## Engineers Comments Regarding Surface Water Drainage

| <b>Application Reference:</b>   | BE/141/25/DOC                                                                                                                 | <b>Reviewer Reference:</b> | ADC/EXT4b  |
| <b>Site Name:</b>               | Land at Oldlands Farm Newlands Road Bognor Regis PO22 9NN                                                                     |                            |            |
| <b>Application Description:</b> | Approval of details reserved by condition imposed under BE/150/22/OUT relating to condition 22-surface water drainage scheme. |                            |            |

243912-BWB-EXT-XX-G-C-0538-[S2-P03]_Drainage Flood Volumes 30yr + 40%
Climate Change Exceedance Plan

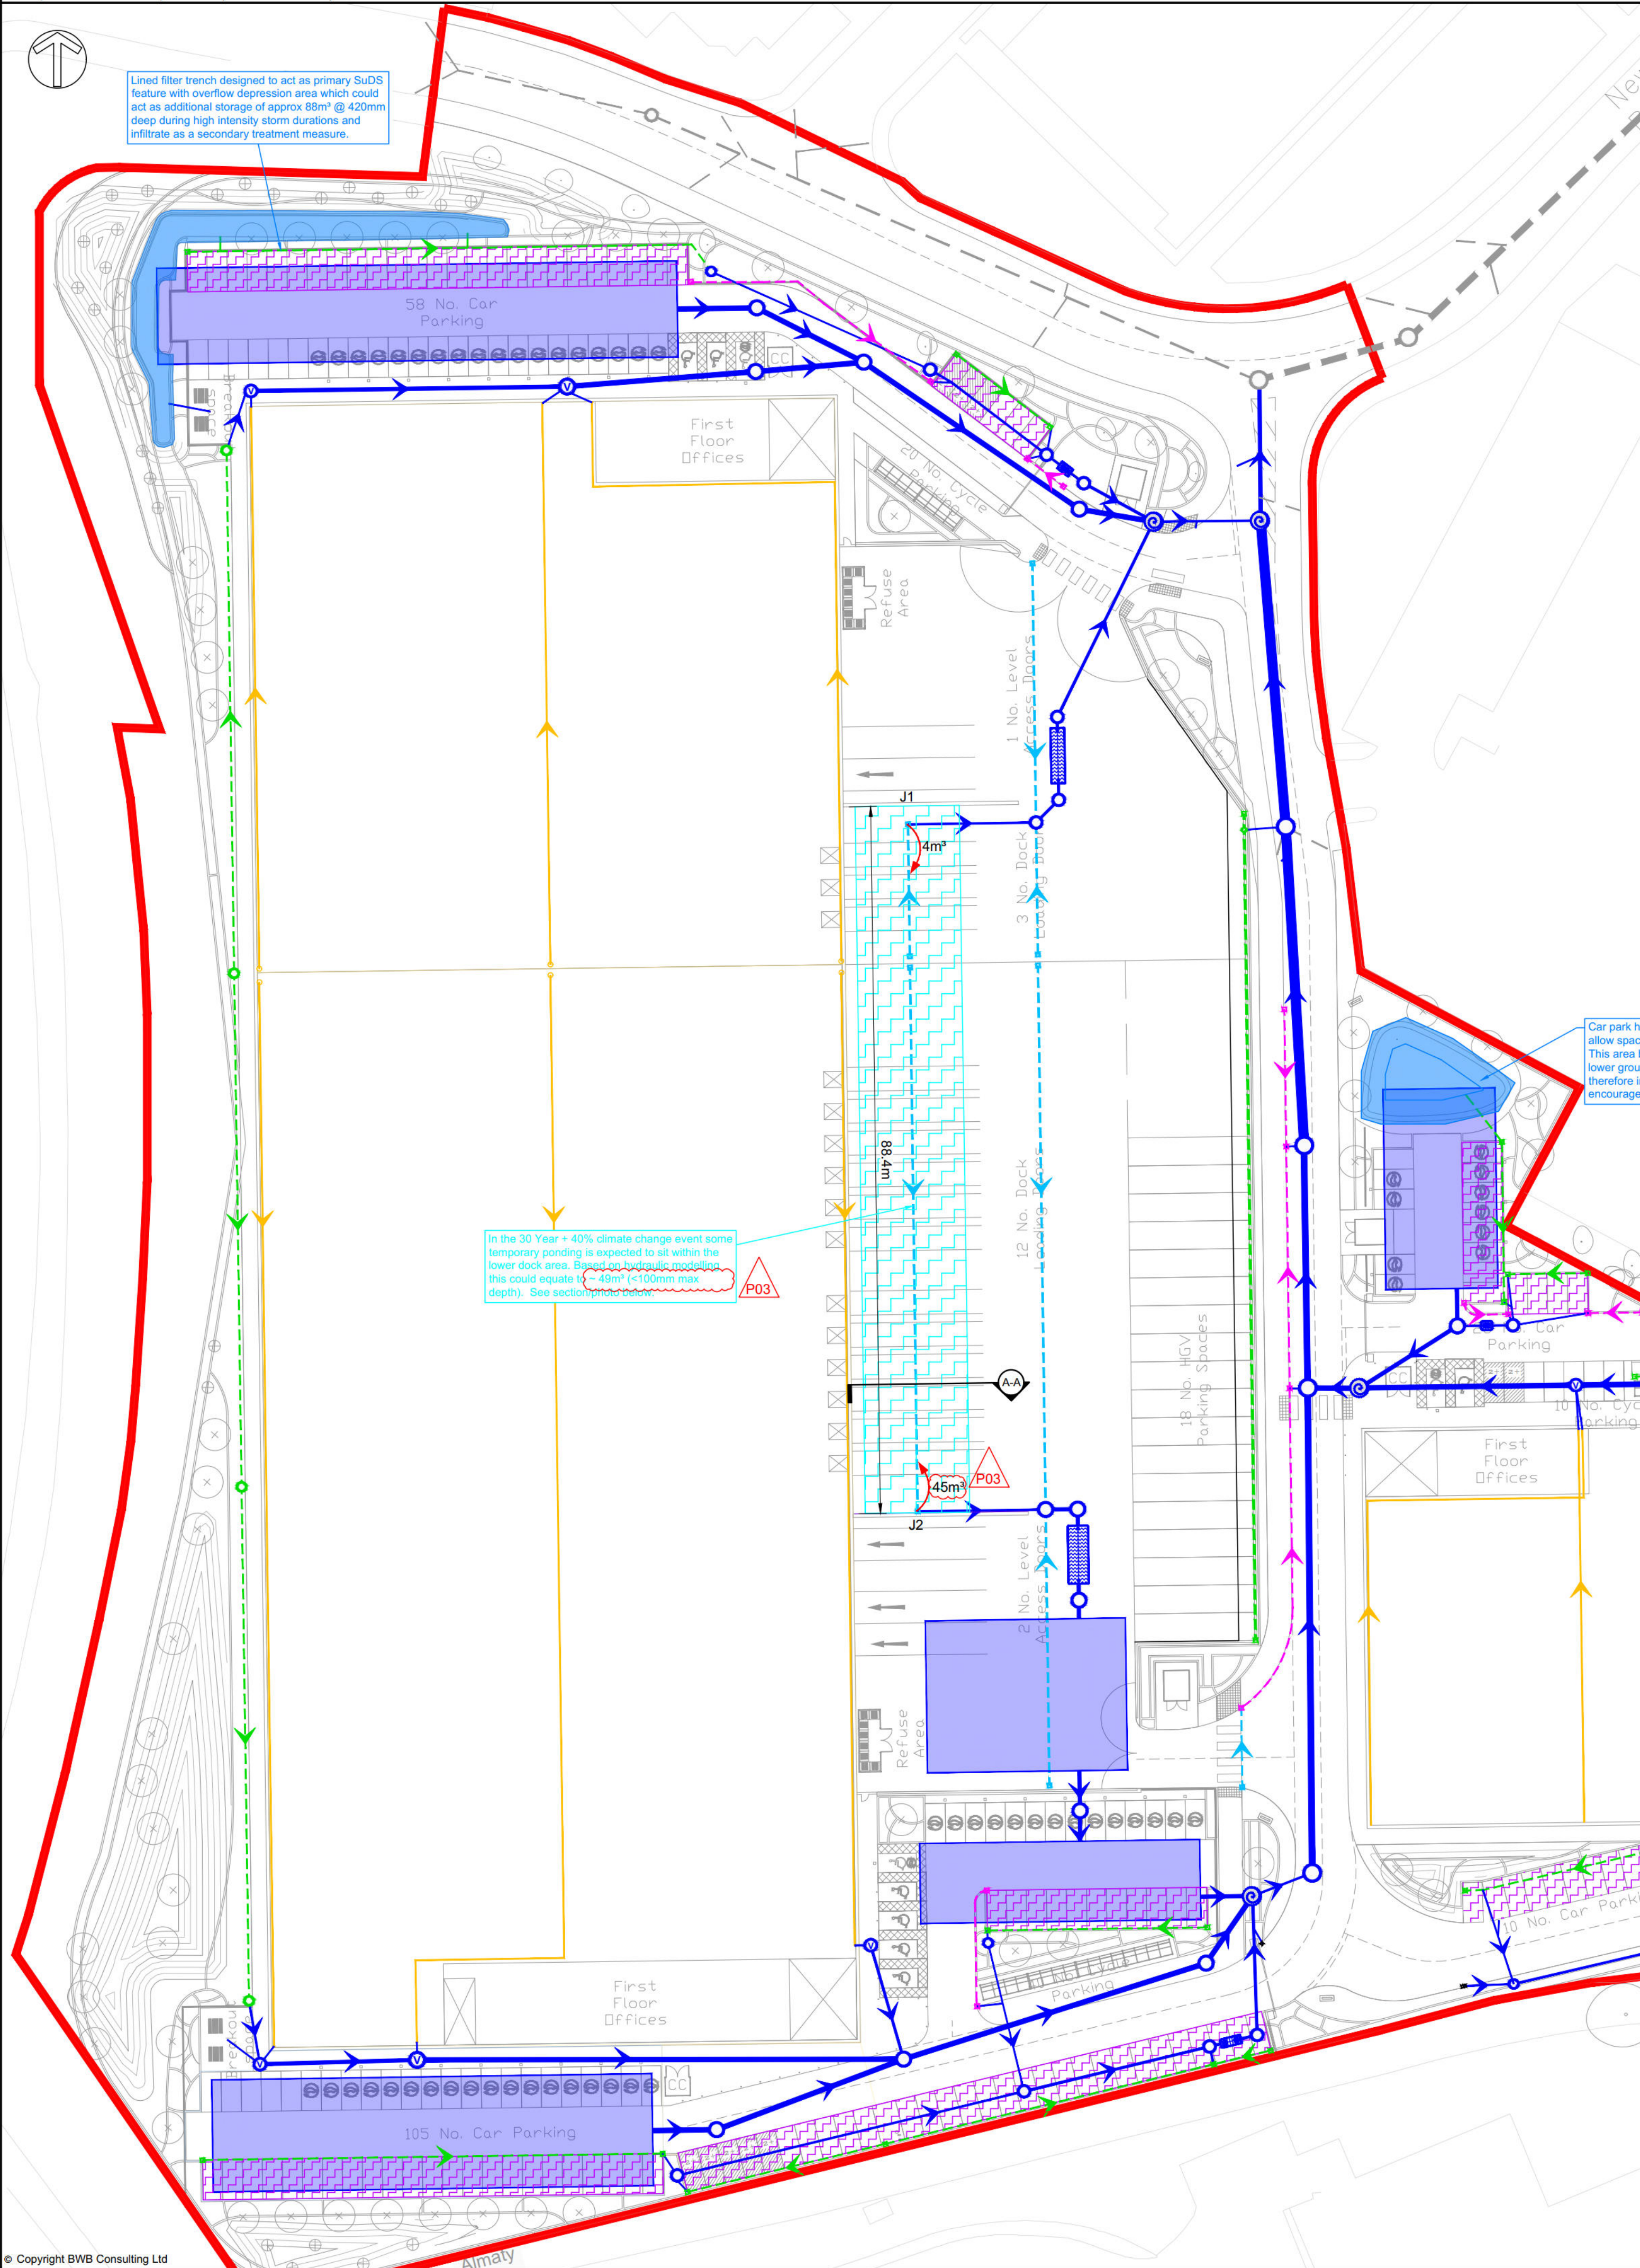
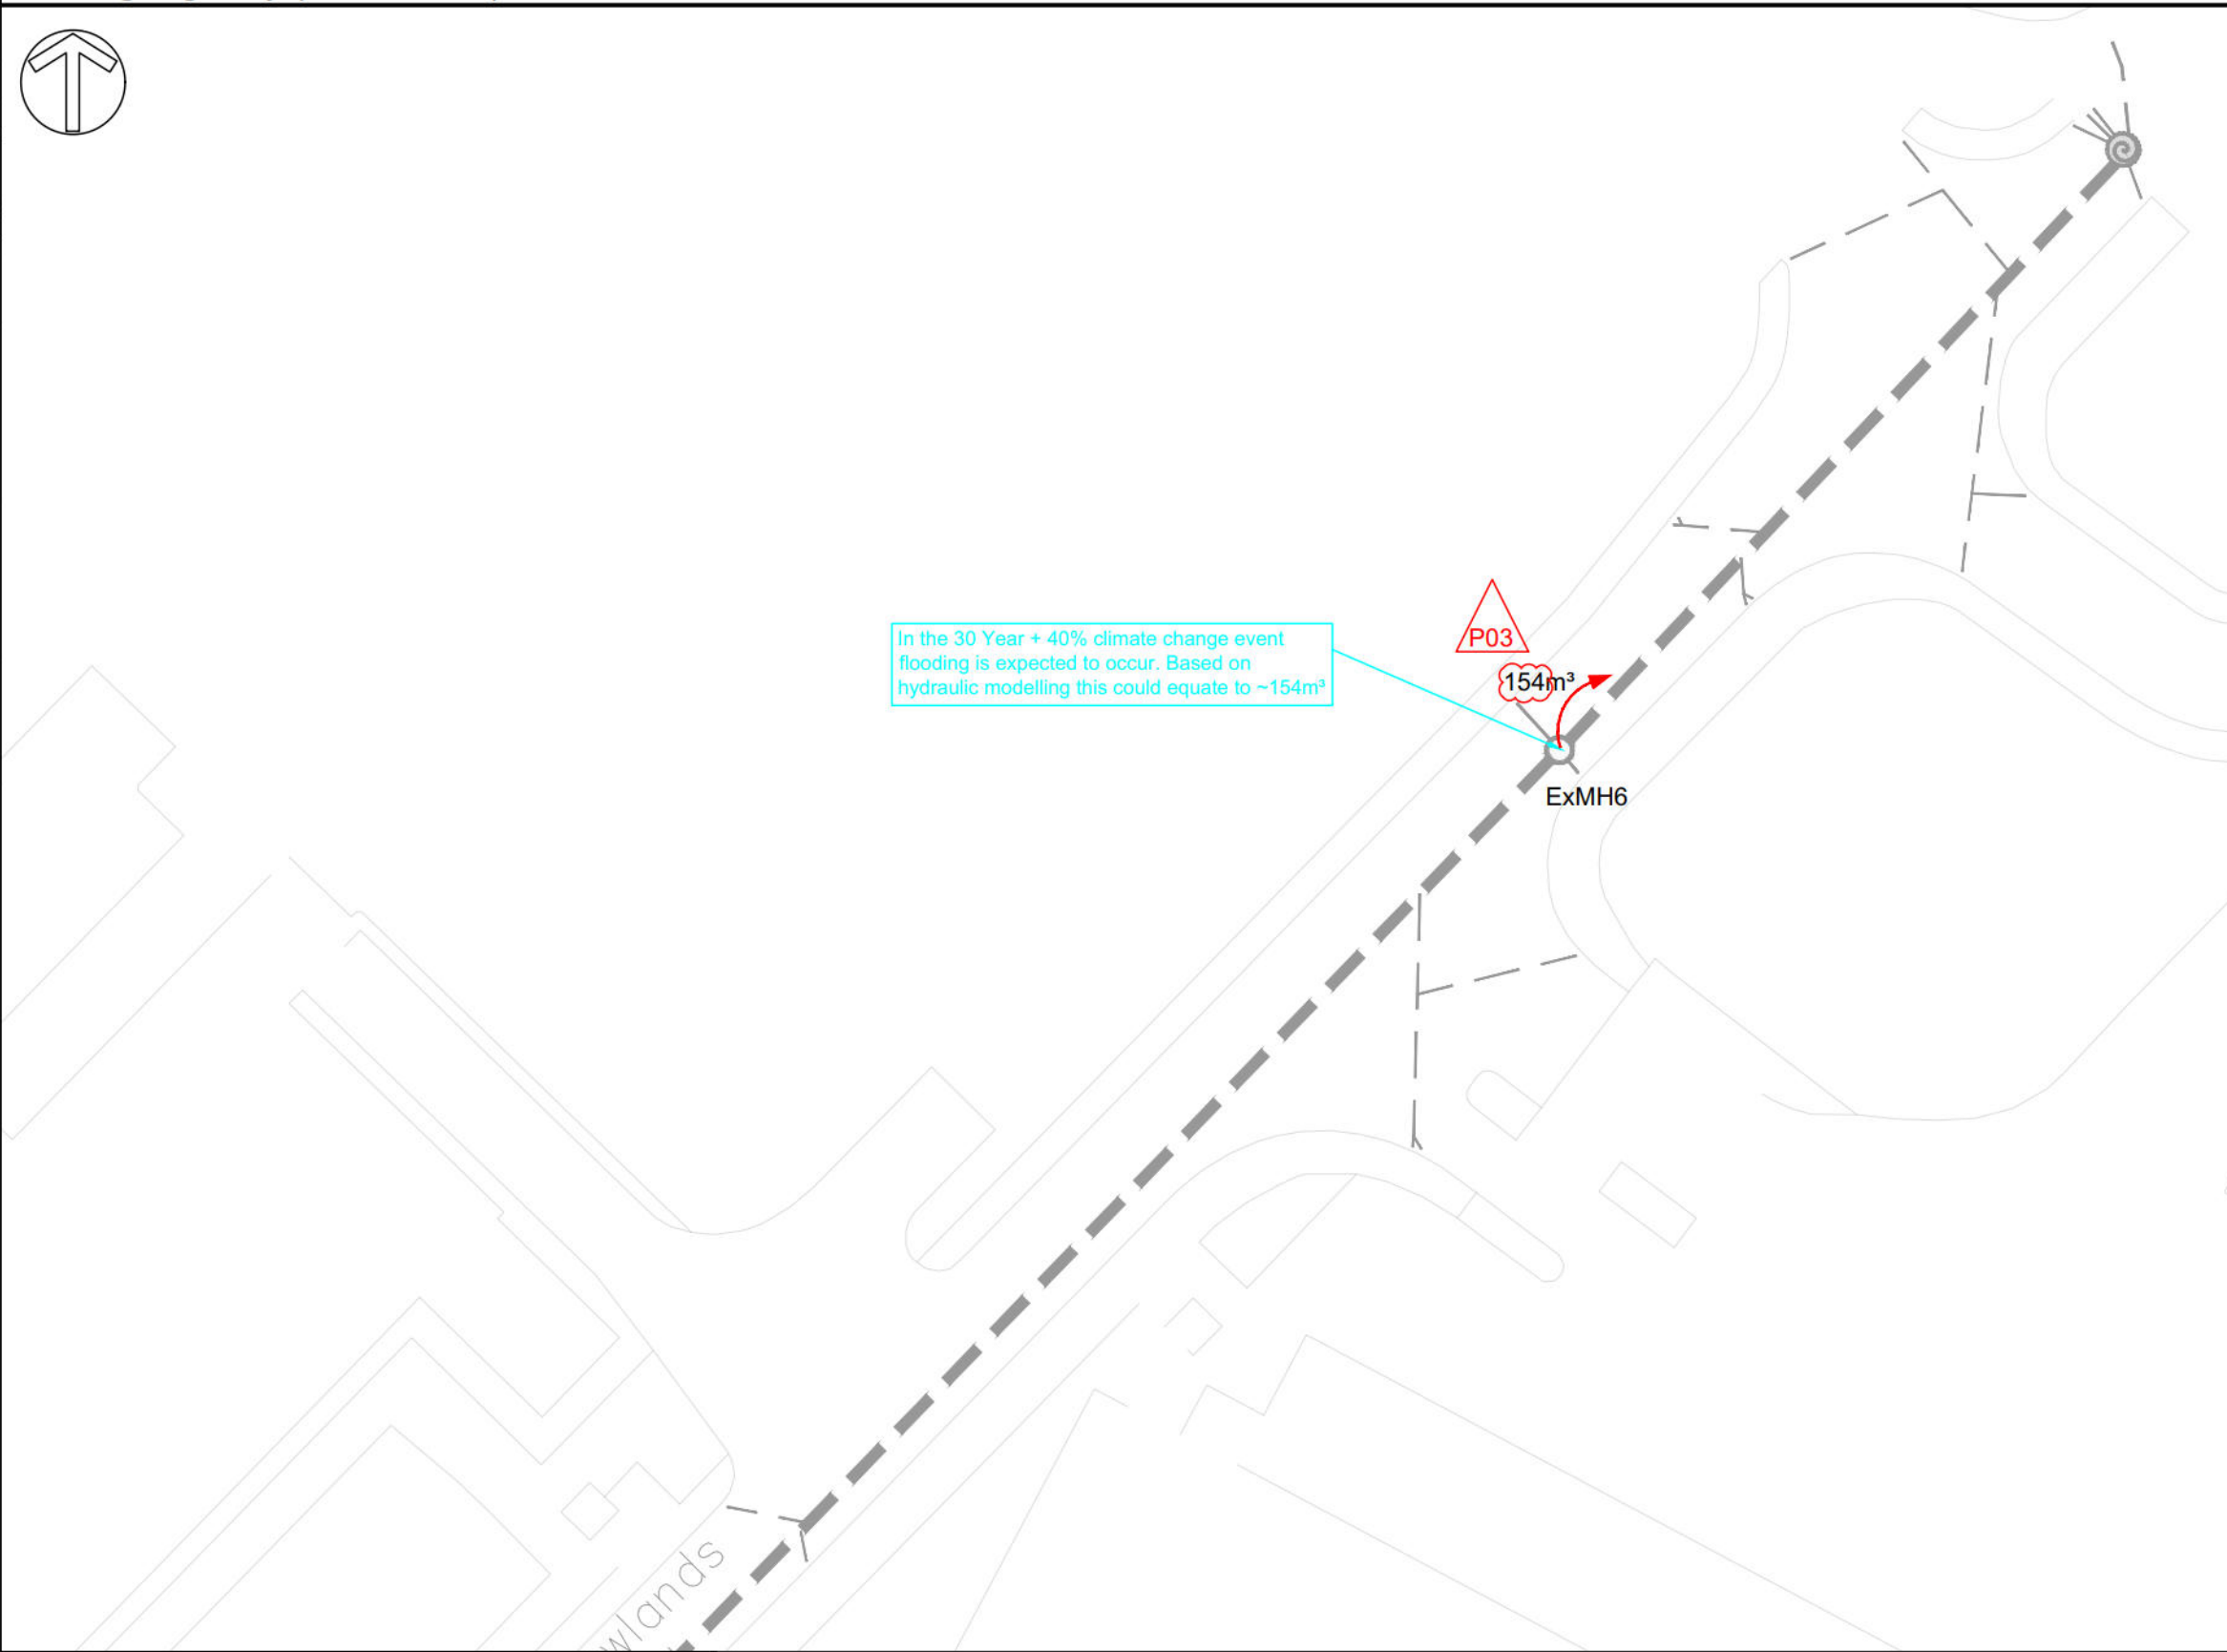
| 12. | <p>The network floods on the critical 3.33% AEP event (both onsite and offsite). This is unacceptable. Please redesign so that the system does not flood for this event.</p> | <p>On-site within the red line boundary the drainage strategy demonstrates that there is no flooding within the 3.33% AEP event (refer to results 243912-BWB-EXT-XX-T-0500-[A4-C08] page 20-22).</p>                                                                                                                                                                                                                                                                                                                                                                                                                                                                                                                                                                                                                                                                                                                                                                                                                                                                                                                                                                                                                                                                                                                                                                                                                                                                                                                                                                                                                                                                                                                                                                                                                                                               |  |  |  |
